Planning Application No: 3/2023/0649

Proposal: Prior notification under Class Q (a) and (b) for the proposed change of use of an agricultural building to two dwelling houses.

Location: Barn adjacent to Tile Croft, Chipping Road, Longridge PR3 2NB

Further to the highway authority's response dated 4 October 2023 to the above application an amended Proposed Site Plan (drawing EAD_152_04 Rev S2) has been submitted.

DRG NO.: **EAD\_152\_04**    REVISION: **S2**

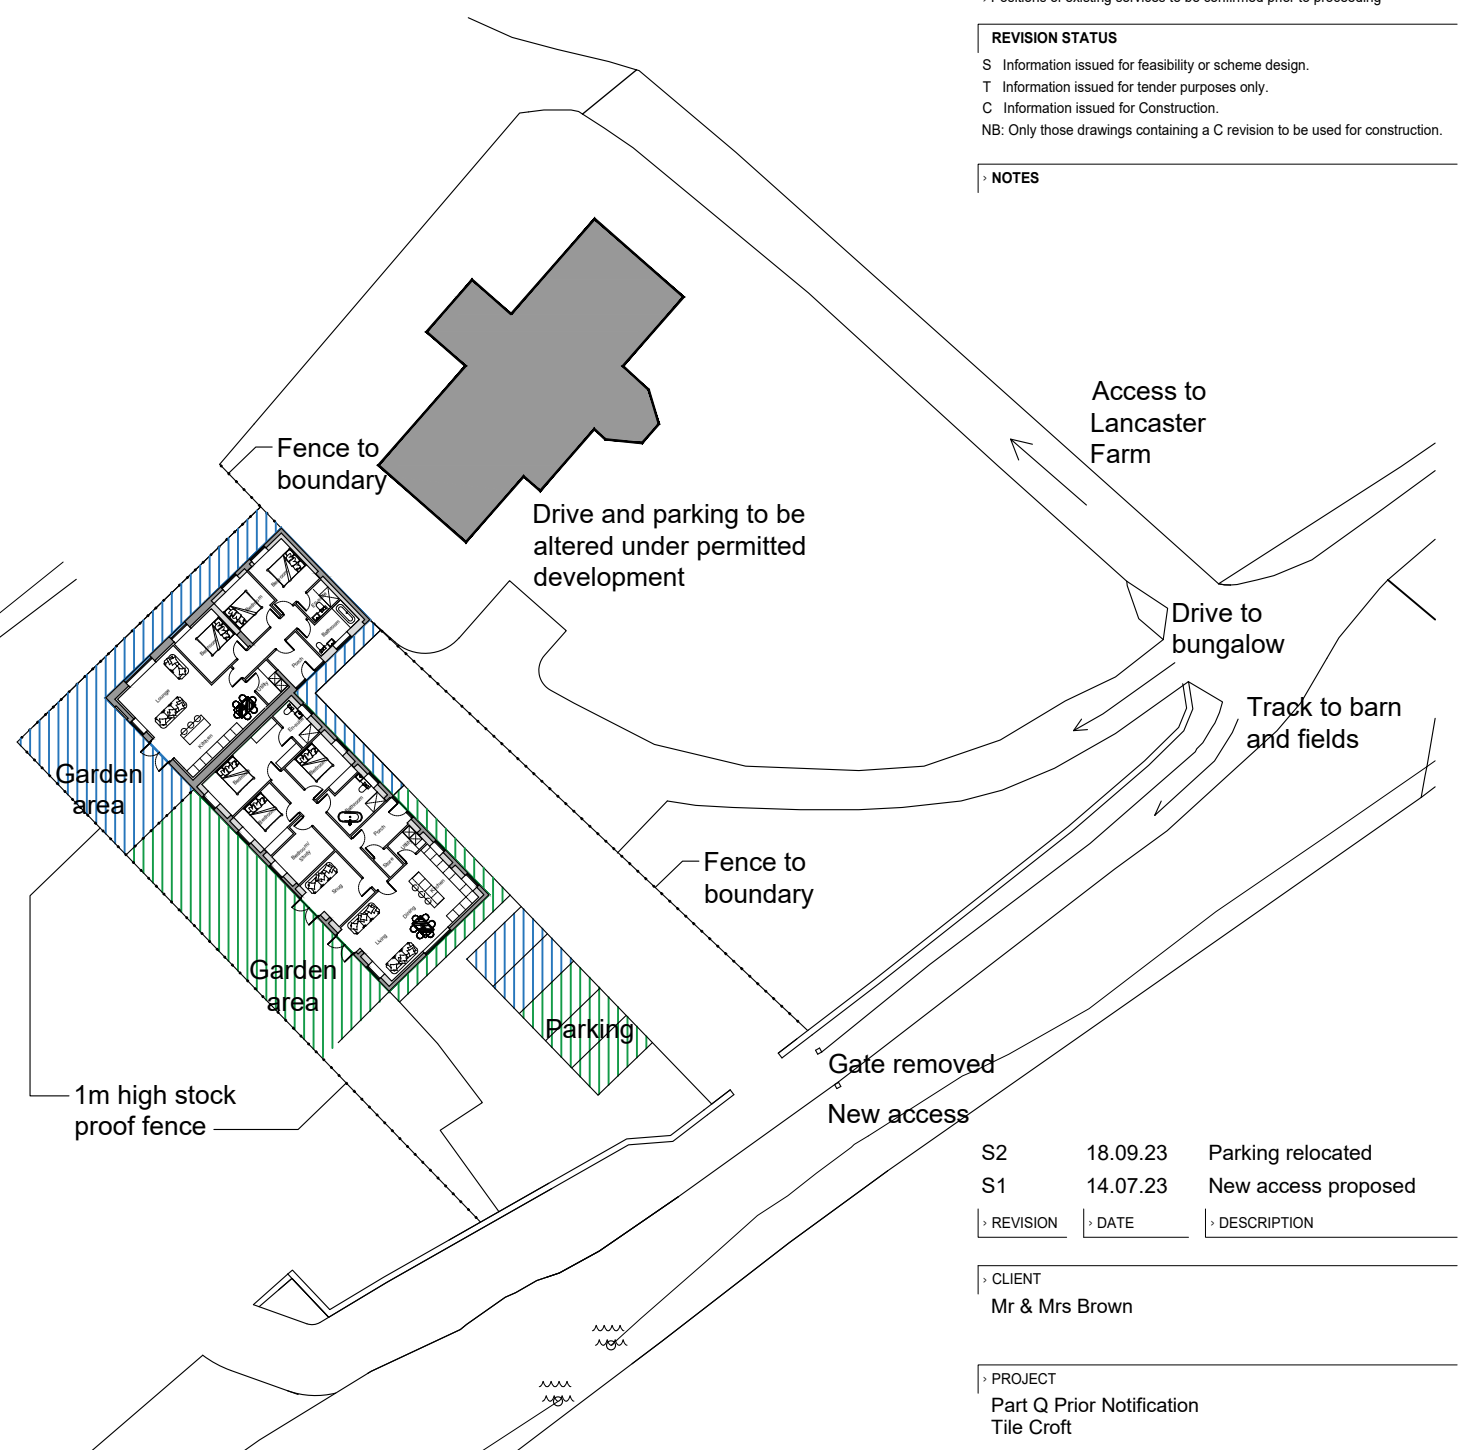
The proposed car parking has been re-located within the site away from the recorded line of Public Footpath ref FP0341068. It would appear that the line of the footpath is no longer obstructed, although as this is not shown on the plan that cannot be confirmed.

Nevertheless, whilst the parking may no longer obstruct the above Public Right of Way the erection of a stock-proof fence to the West would still prevent its use.

As stated in its previous response, until the county council's Public Rights of Way section confirms that it has no objection to the development the highway authority must maintain its own objection.
